Office of
Environment
& Heritage

Our Ref: DOC15/505335

Re: Cudgen Lakes Sand Project – Modification 1 Invitation to Comment

Enclosure: OEH Recommended Requirements for Cudgen Lakes Sand Project – Modification 1

Figure 3: Proposed temporary processing area and activities

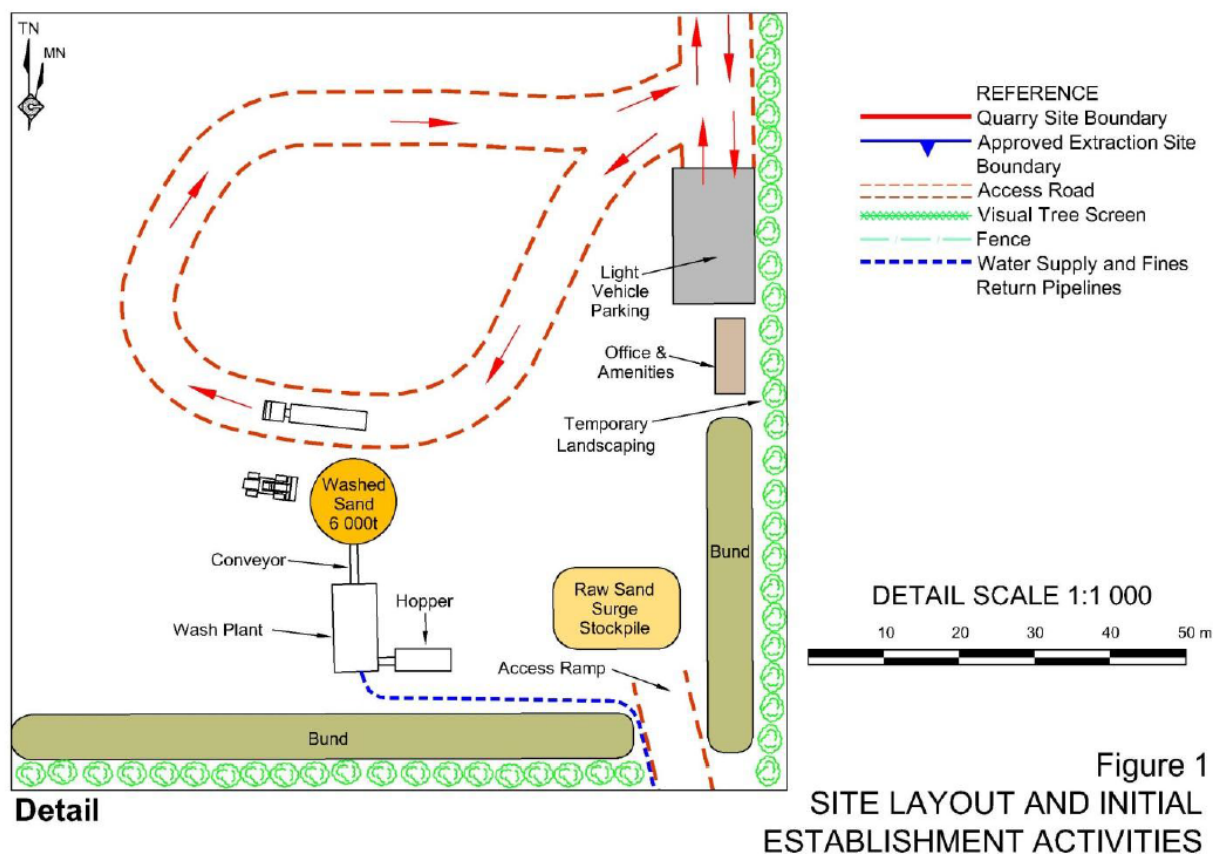
The OEH recommends, that, prior to the determination of the Modification the proponent undertakes a detailed flood impact assessment of the proposed filled area and particularly the 2m high bund. The flood impact assessment should include the following:

- Description of the flood assessment and modelling undertaken in determining the design flood levels for events, including a minimum of the 10% AEP , 1% AEP and the probable maximum flood events (or an equivalent extreme event) for both the local catchment and Tweed River flooding.
- The impact of the proposed project on existing flood behaviour for a flood events mentioned above.
- Impacts of the development on flood behaviour resulting in detrimental changes in potential flood affection of other developments or land. This may include redirection of flow, flow velocities, flood levels, hazards and hydraulic categories.
